**From:** [Downes, Scott G \(DFW\)](#)  
**To:** [Jeremiah Cromie](#)  
**Cc:** [Torrey, Elizabeth M \(DFW\)](#)  
**Subject:** RE: RU-22-00001 Ski Acres Estates - Notice of Application WDFW Comments  
**Date:** Thursday, March 31, 2022 2:51:04 PM

**Subject:** RE: RU-22-00001 Ski Acres Estates - Notice of Application

MITIGATION SITE PLAN

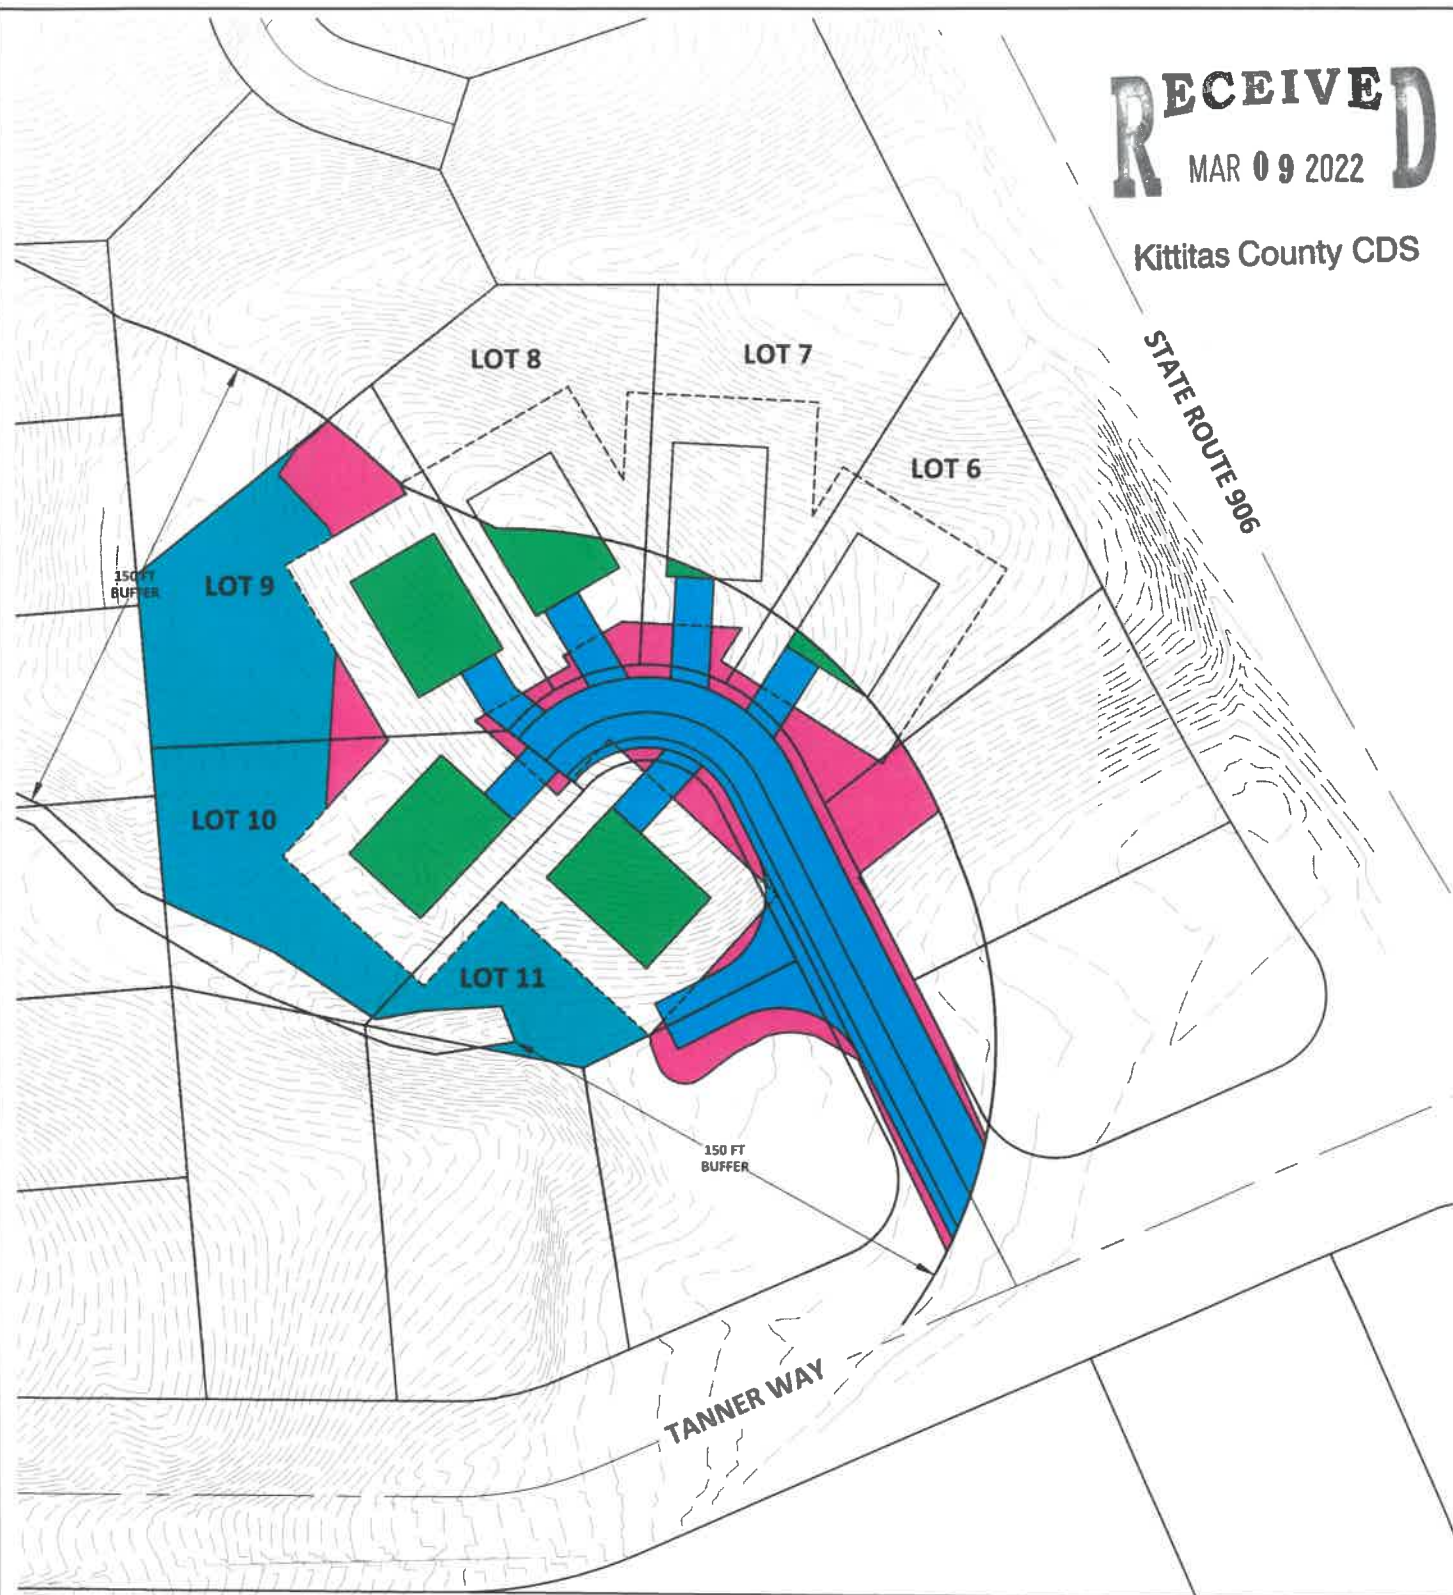
WDFW previously commented on this project, and held a site visit with the applicant and Kittitas County where impacts and stream typing were discussed. If reasonable use is accommodated here, WDFW is not objecting to a potential mitigation plan to ensure no net loss of function to the riparian area yet allow for the building. However, that mitigation plan must consider the various habitat elements of the riparian area such as habitat complexity, mature trees for shade etc.. The mitigation plan talks of replanting and the Sewall report mentions such details as large woody debris and planting of the creek banks, yet no details on where that is occurring or what trees need to be taken out are shown on the included plans. Thus WDFW does not have enough information to determine if this is an acceptable mitigation plan for reasonable use or not to offset its impacts to FWHCA CAO function. We respectfully ask that this decision be tabled until more detailed plans and a site visit to discuss those plans can be worked out between the applicant, Kittitas County and WDFW (who is a technical expert to Kittitas County on the matter of FWHCA). Those details such as trees being removed (and their size) and exactly where these habitat elements to mitigate for the loss are being installed need to be shown in detail.

Thank you. Please have the applicant send us further details and arrange a site visit to discuss those details.
